Bulk Recovery Solutions Pty Ltd – Ingleburn Facility – SSD 8593

I refer to the email dated 7 June 2019 from Jessica Fountain to the Environment Protection Authority (EPA) regarding the notice of exhibition for the Ingleburn Resource Recovery Facility under SSD8593 (Proposal).

MEGAN WHELAN
Unit Head Waste Compliance
Environment Protection Authority

REV	DATE	DRN	CHK	APP	DRAWING STATUS

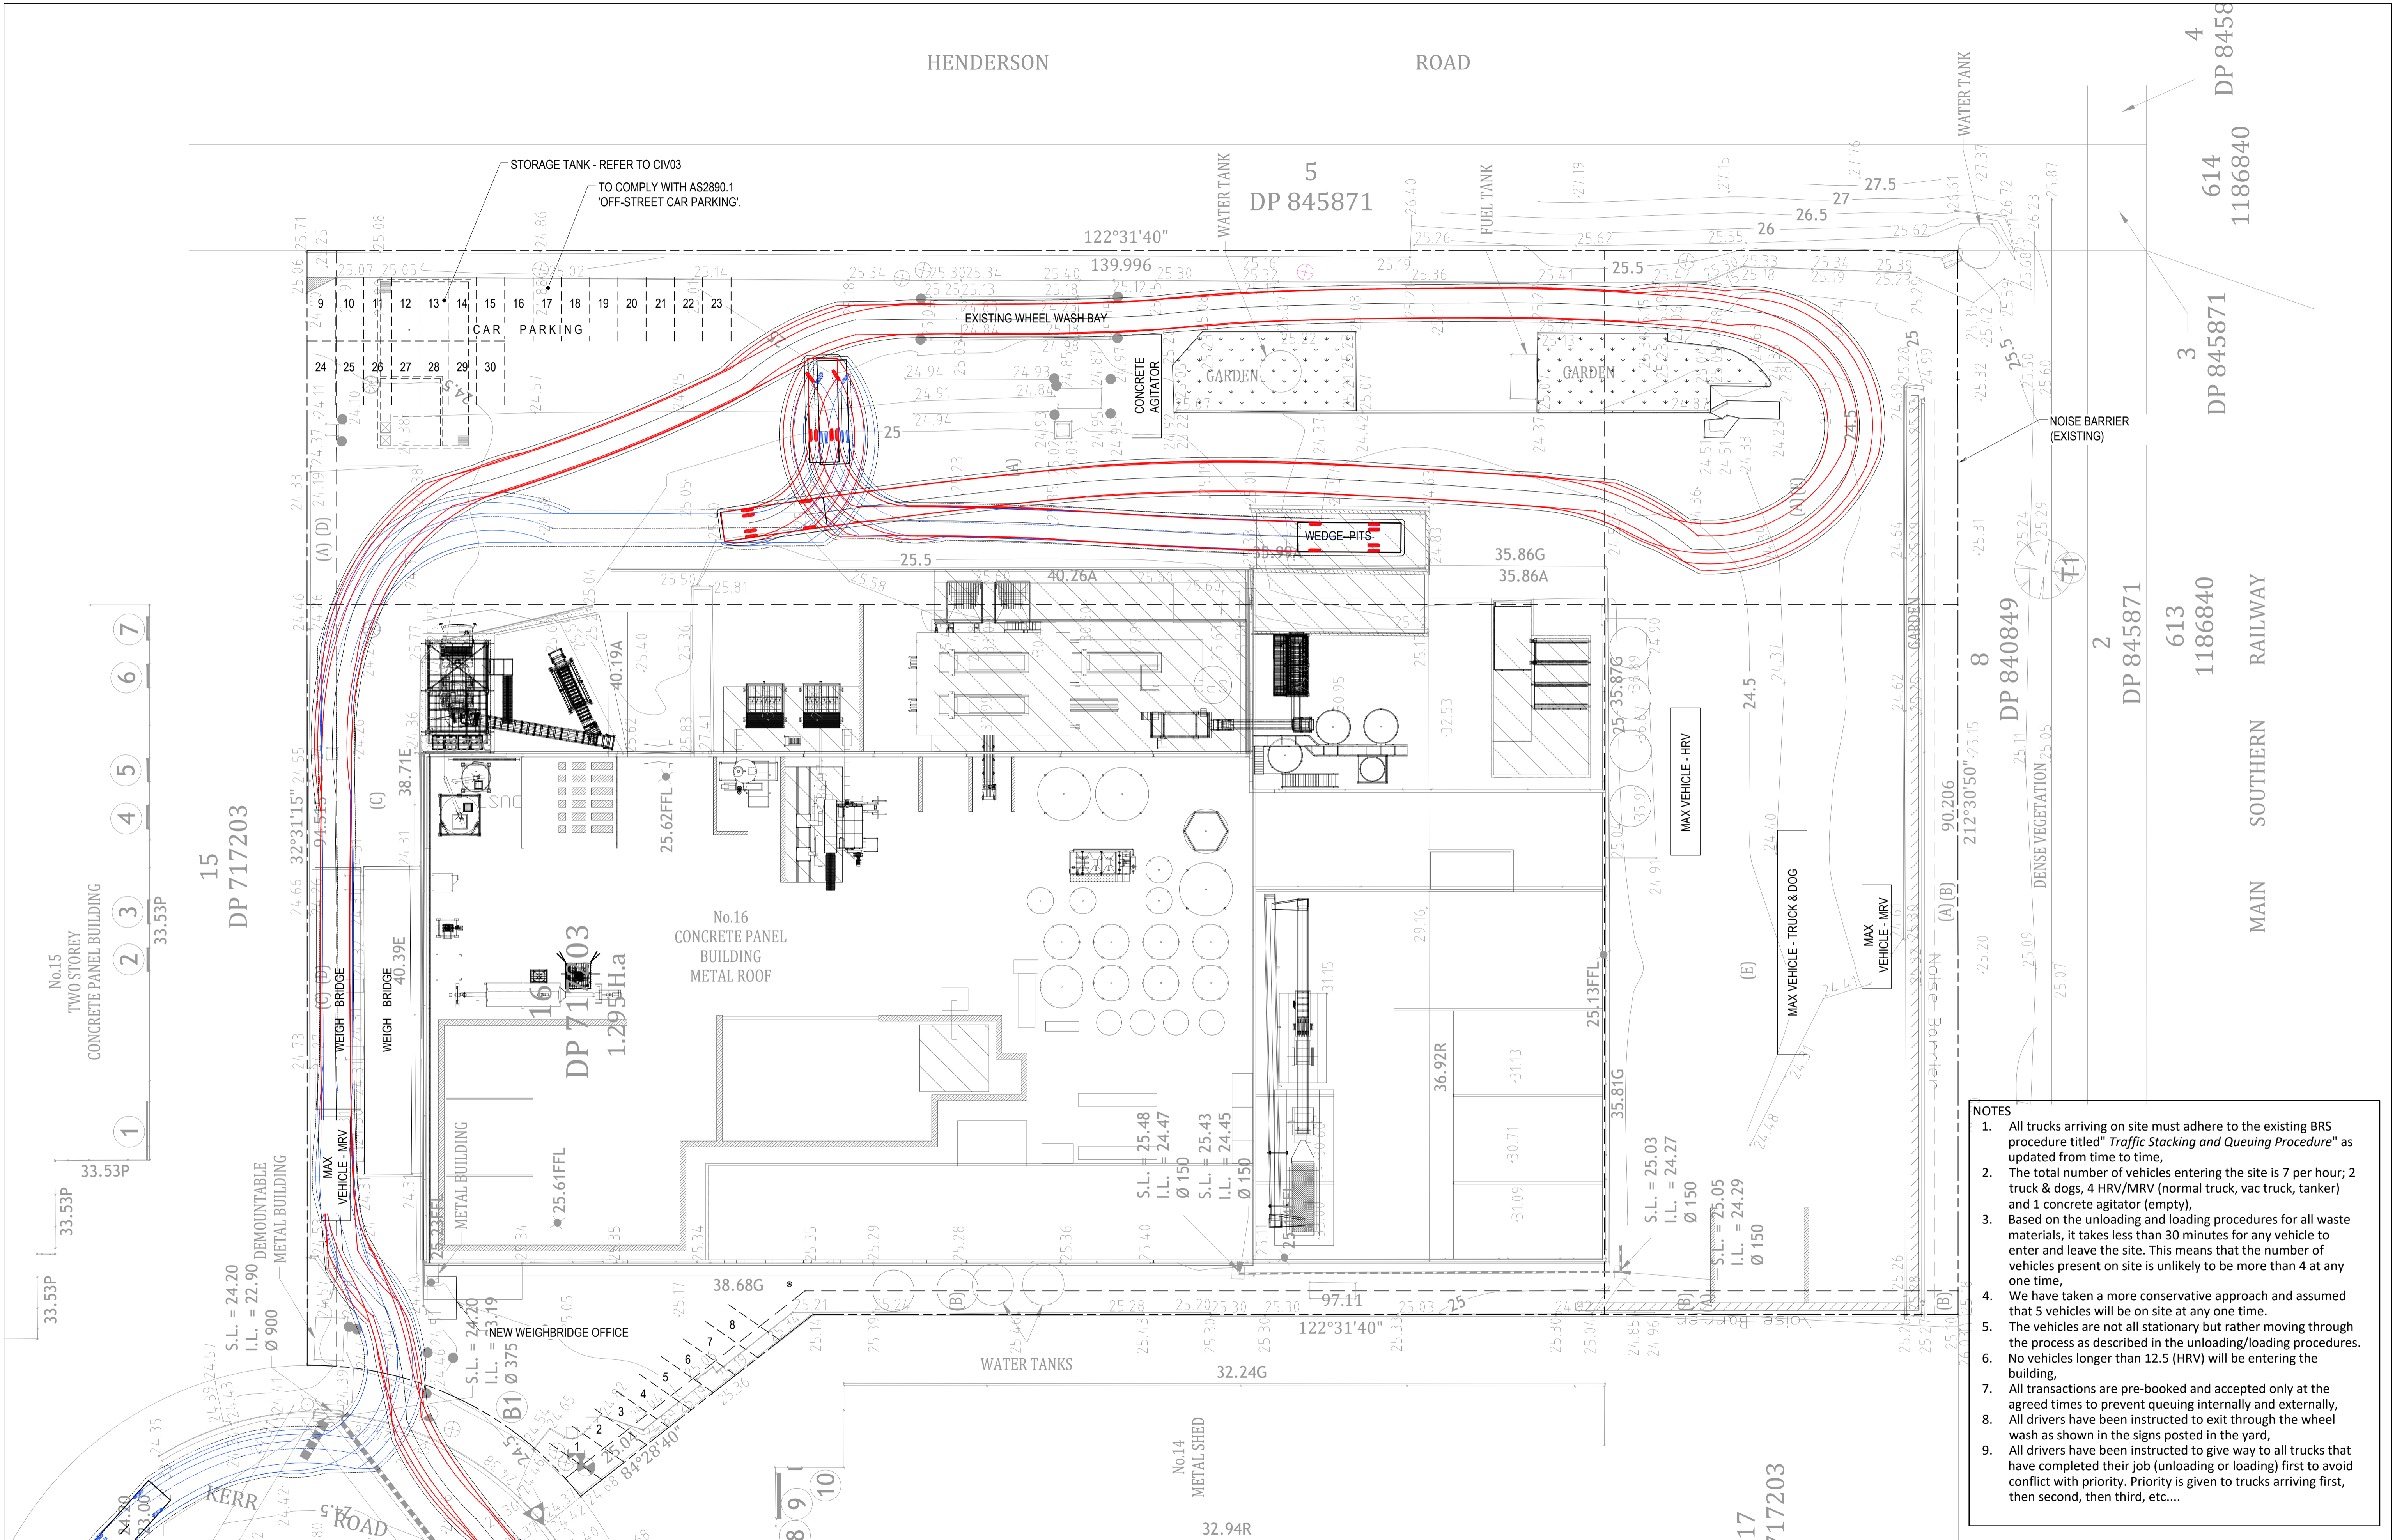
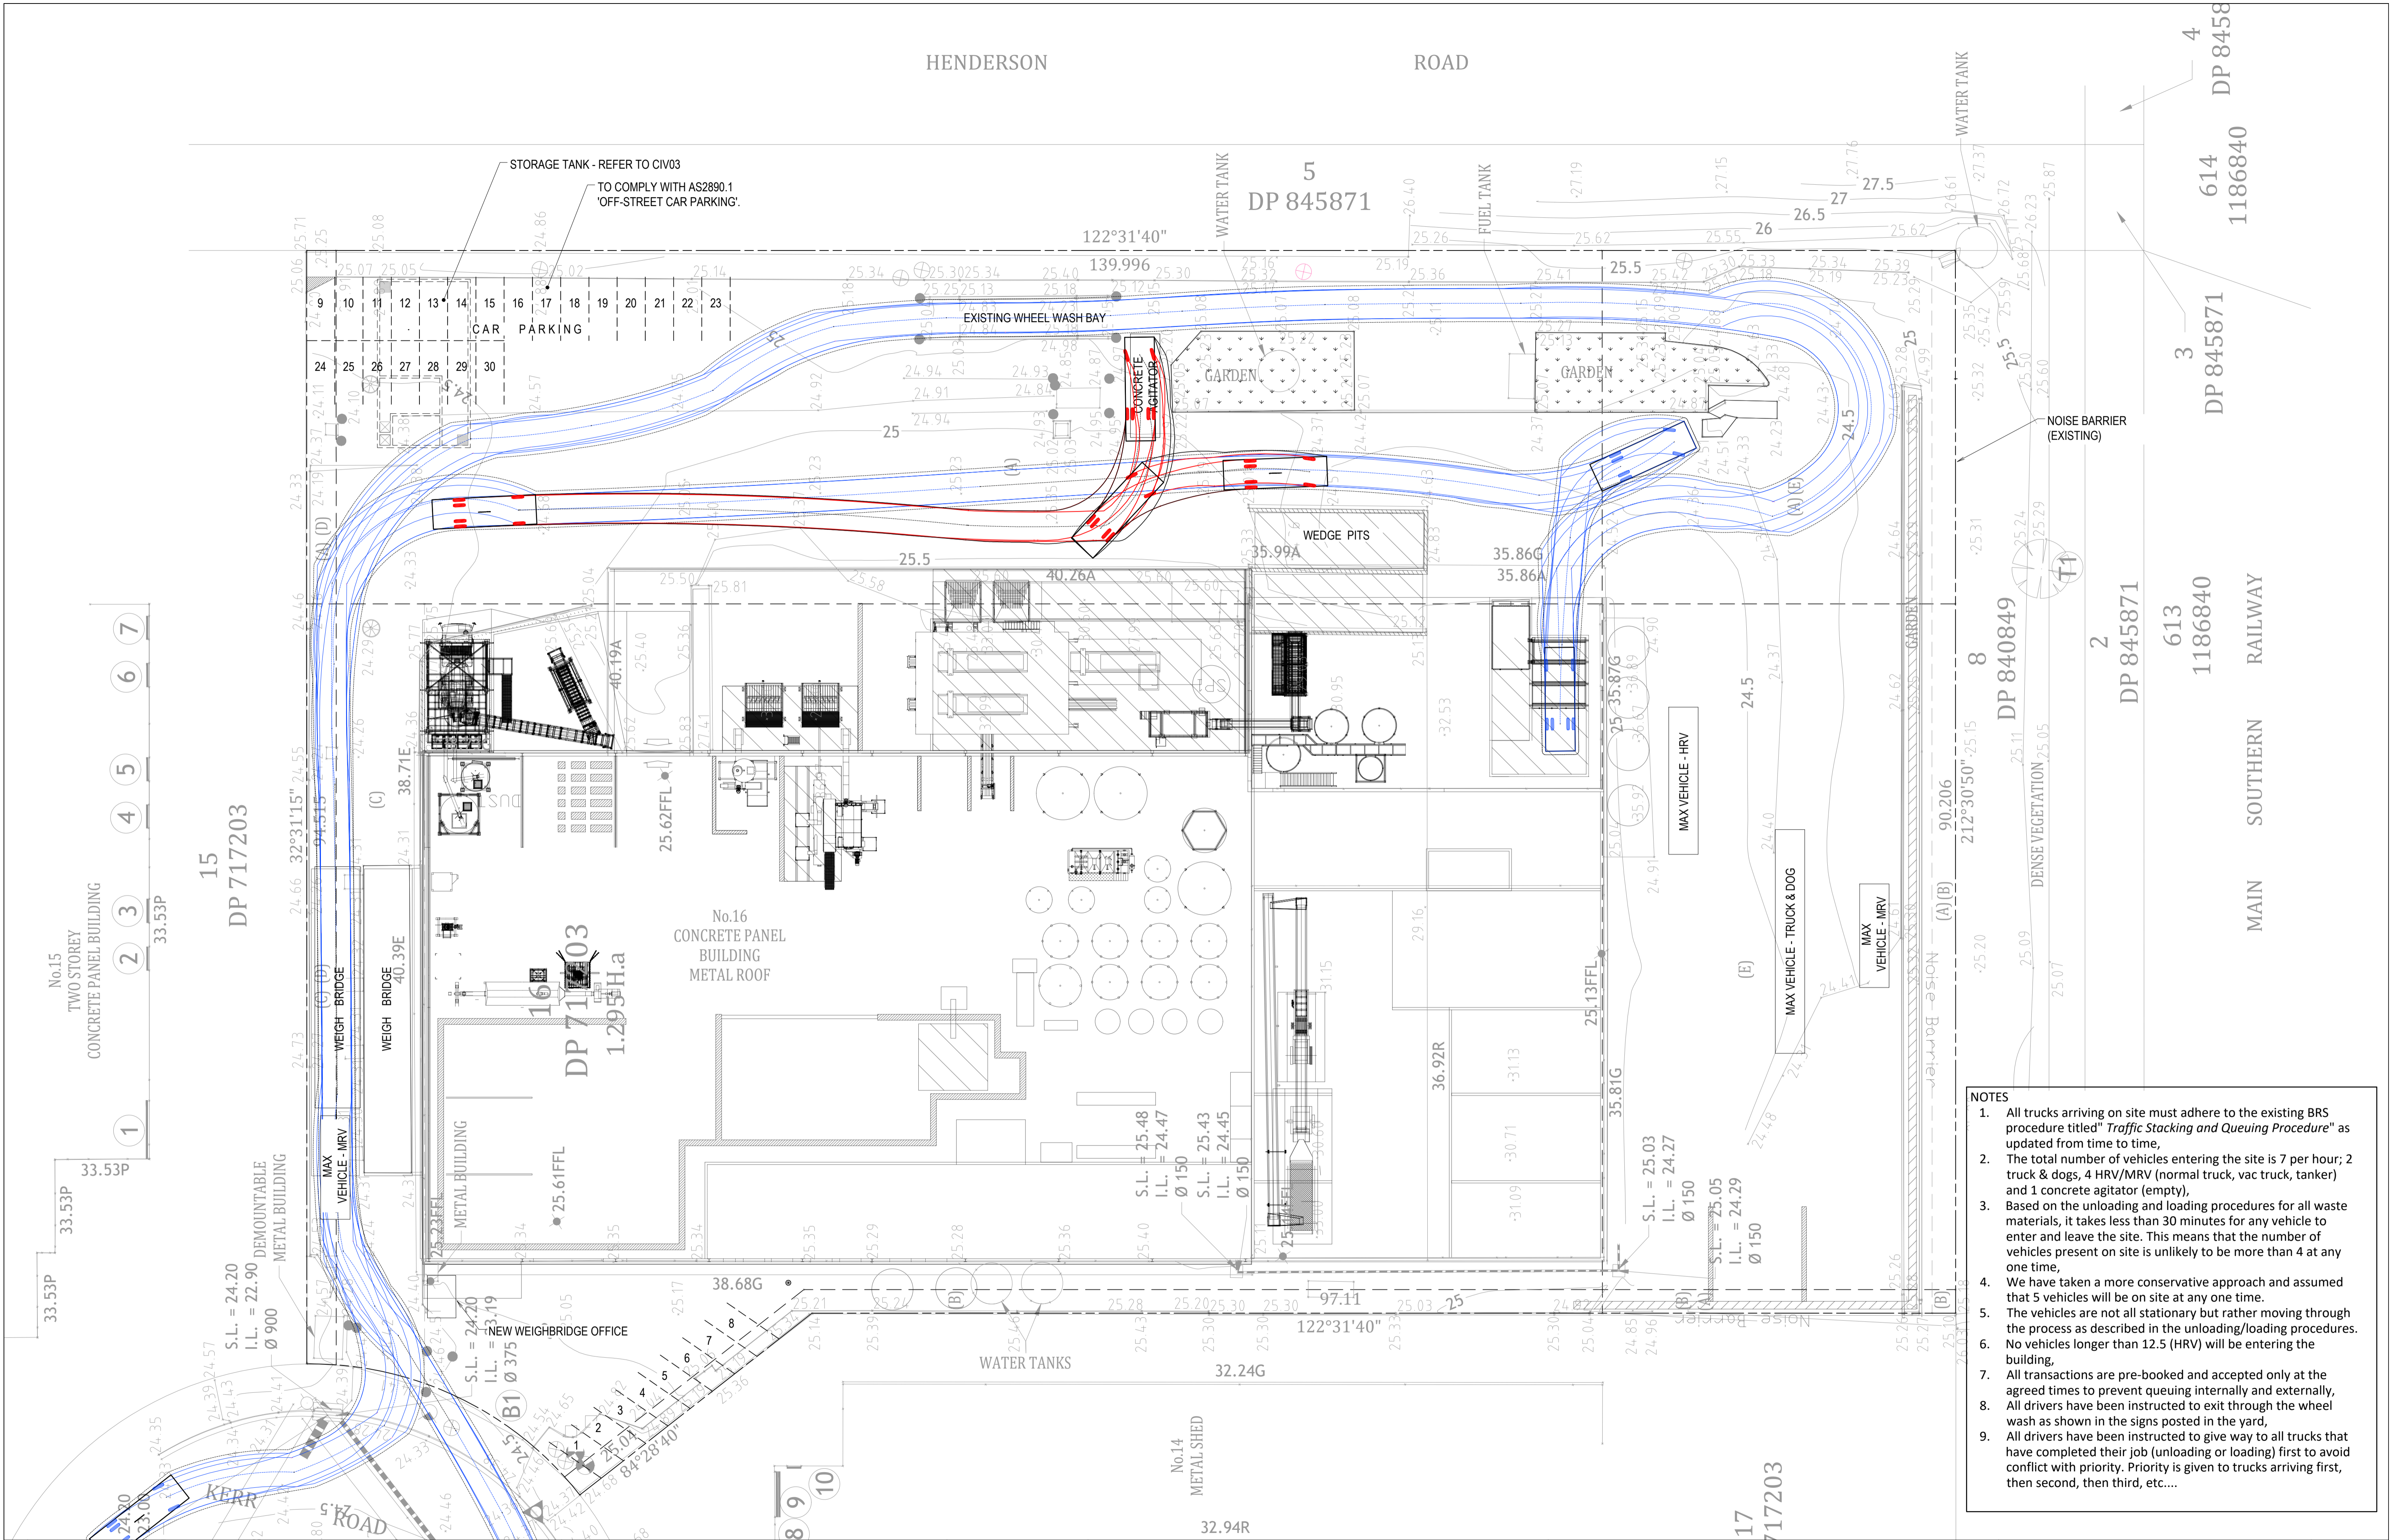
- A number of the plans submitted by the proponent detailing vehicular movement within the site show vehicle paths directly through the nominated receivals area for solid waste. We require further information detailing how the proponent will meet the EPA's minimum standards for managing construction waste in NSW, given the limited space available.
